Subject: RE: CM/17/20/DOC - Ryebank Farmhouse

CM/17/20/DOC

Approval of details reserved by condition imposed under ref CM/45/19/PL relating to Condition No 4 - details of railings and the flint/brickwork

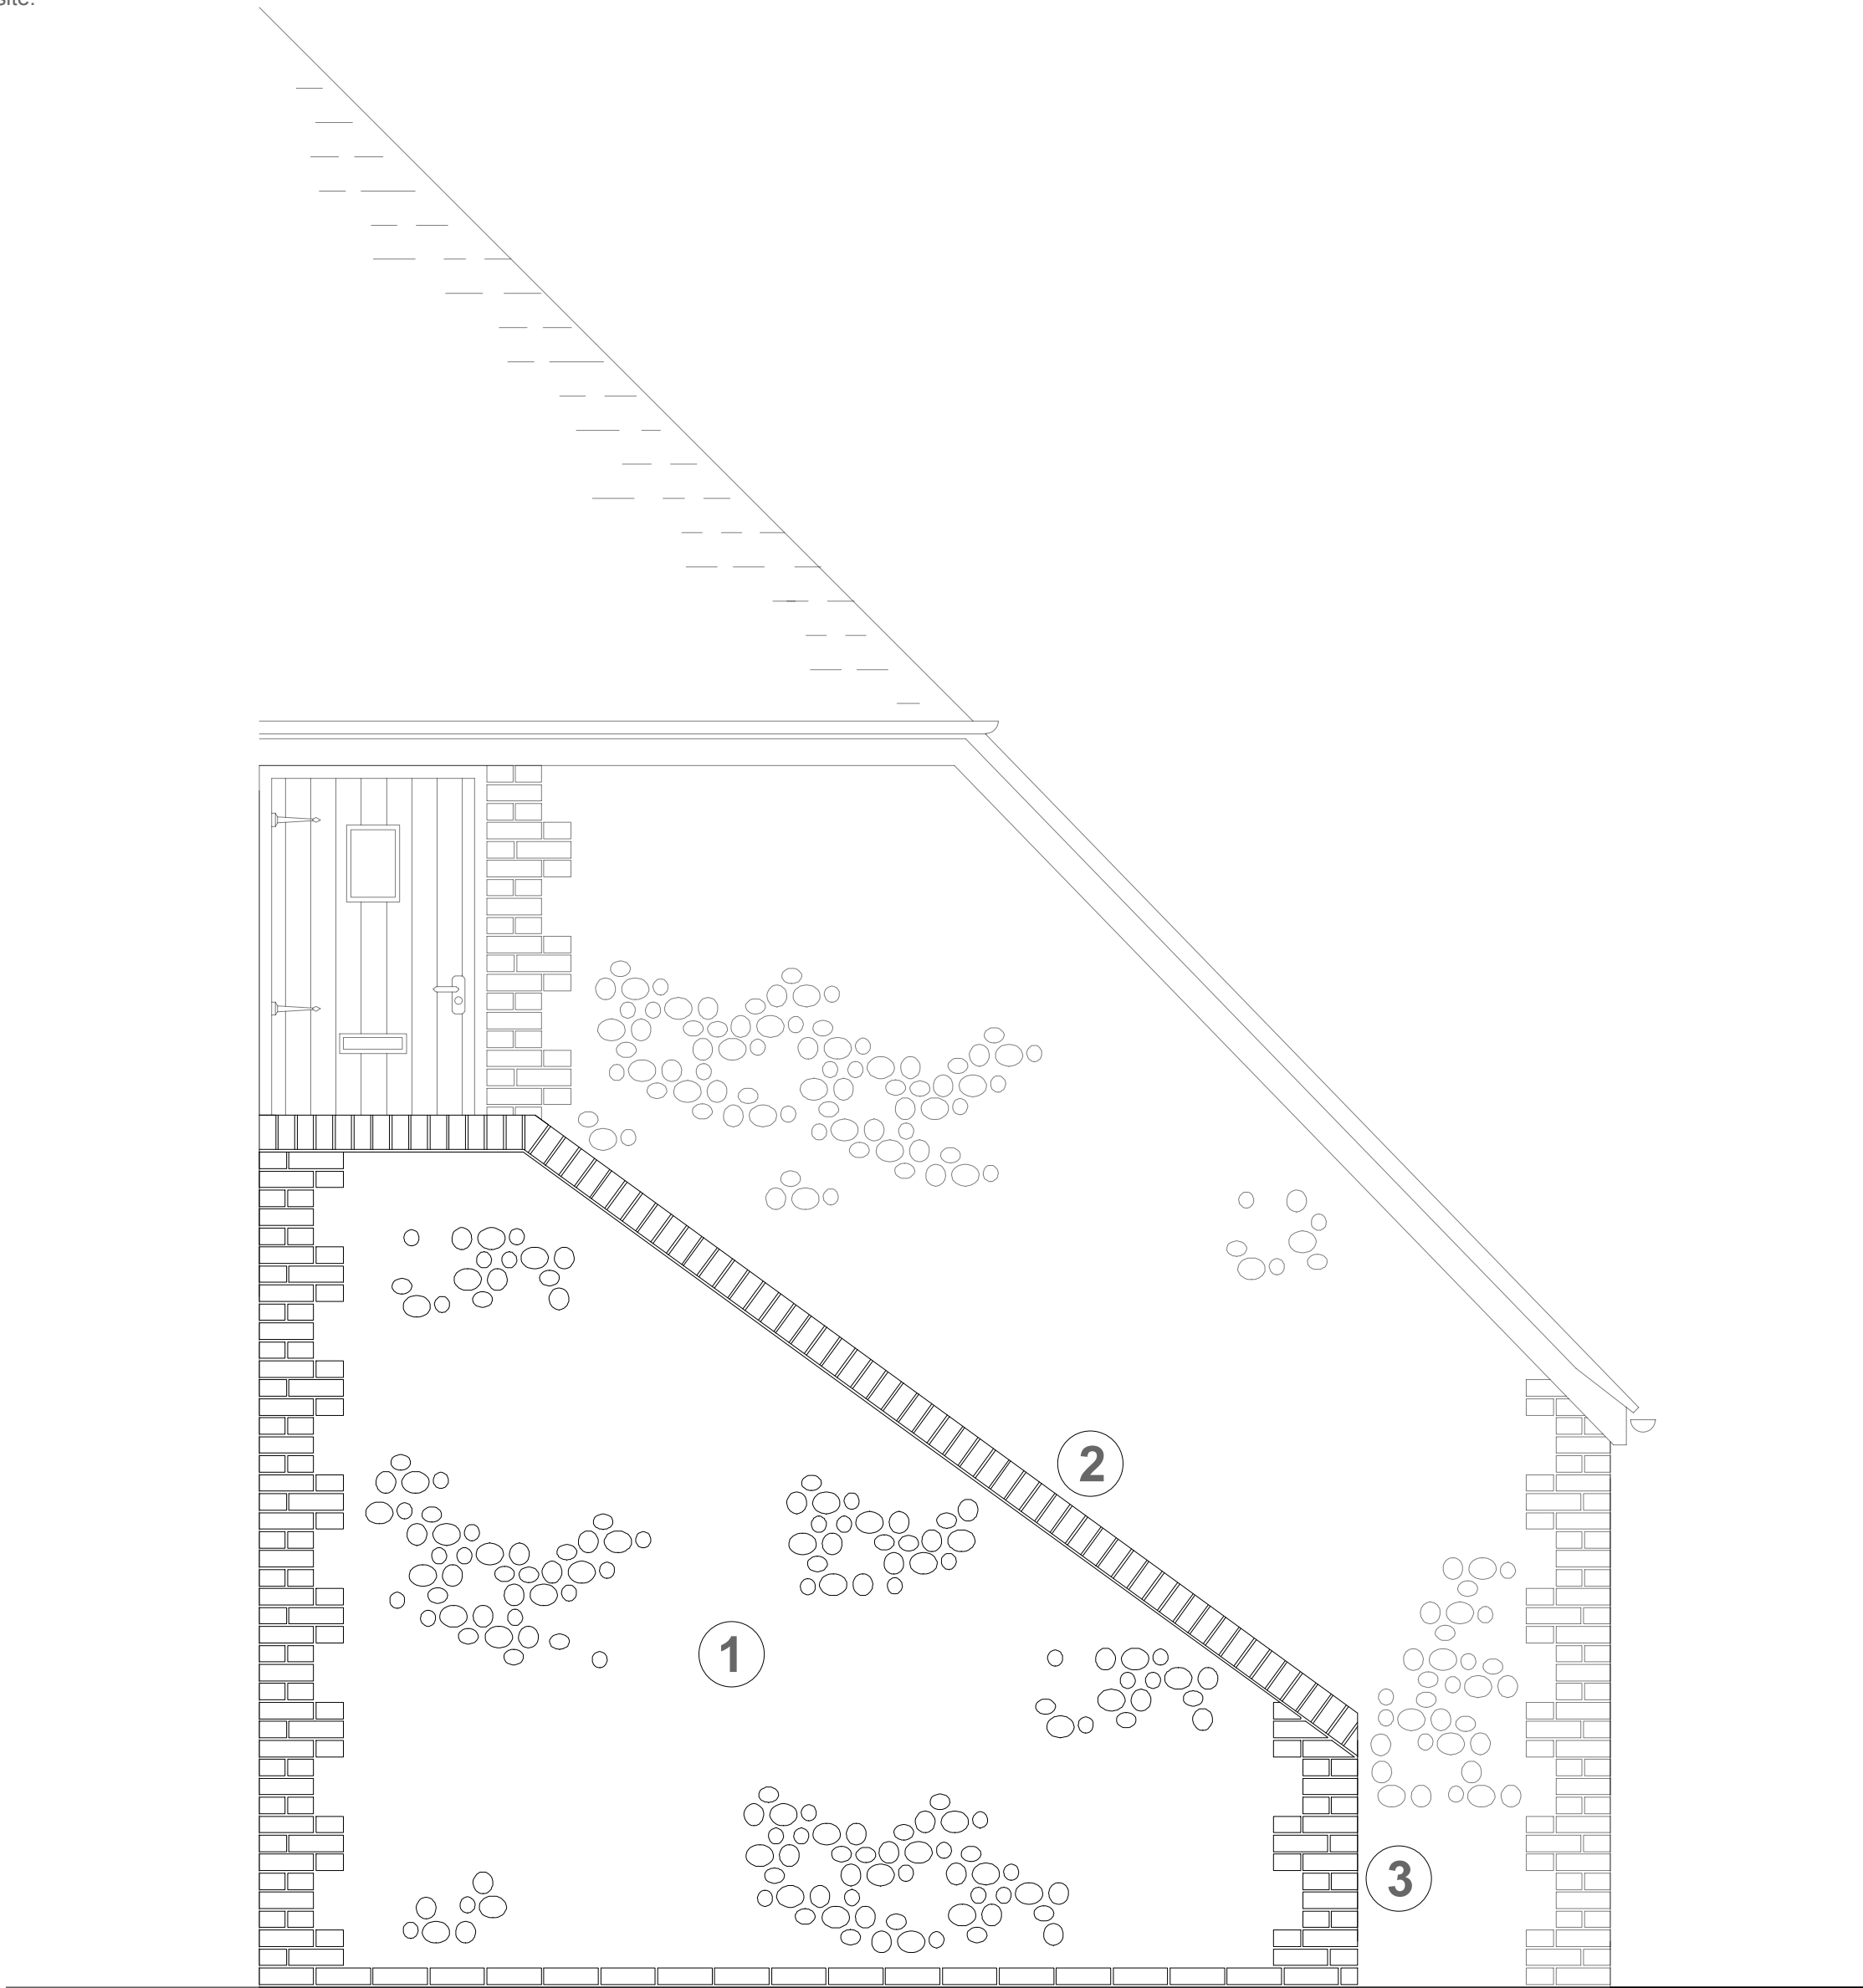
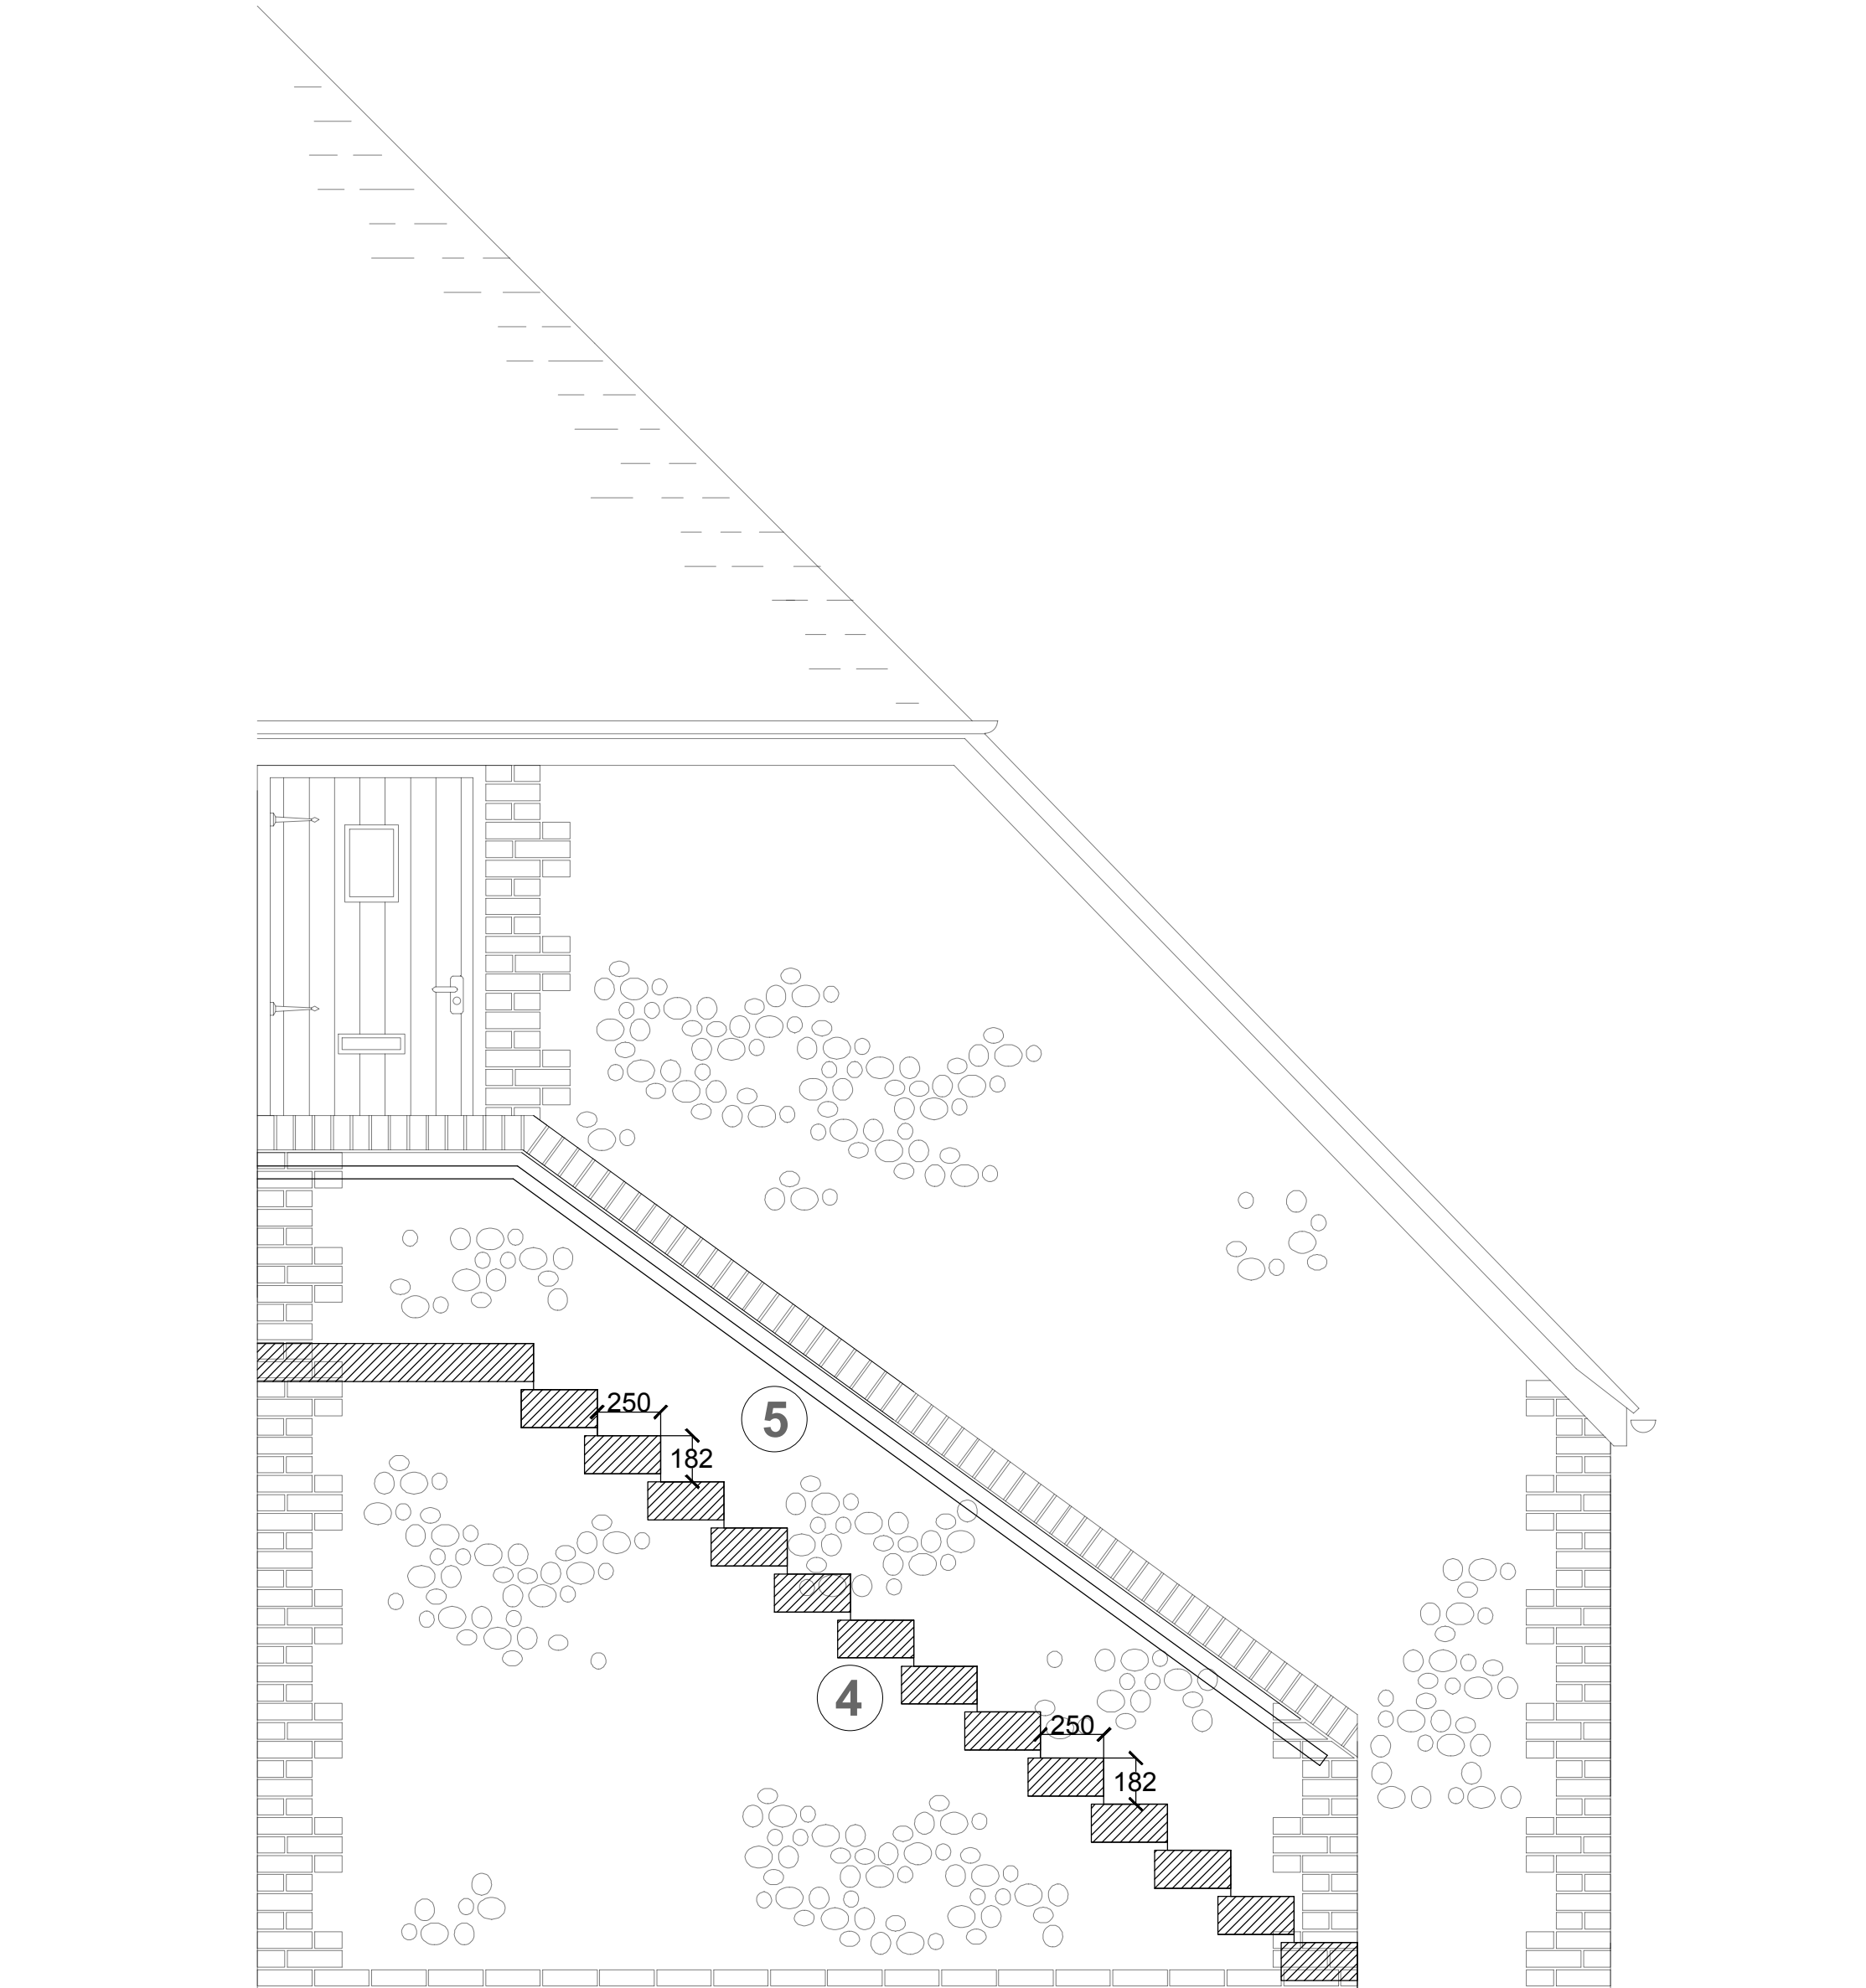
Details are provided for in plan and pictorial format. The proposal for the new flint work to match existing (laid coursed using locally sourced cobbled & napped flints, laid in hydraulic lime mortar), the materials and handrail all appear to be acceptable.
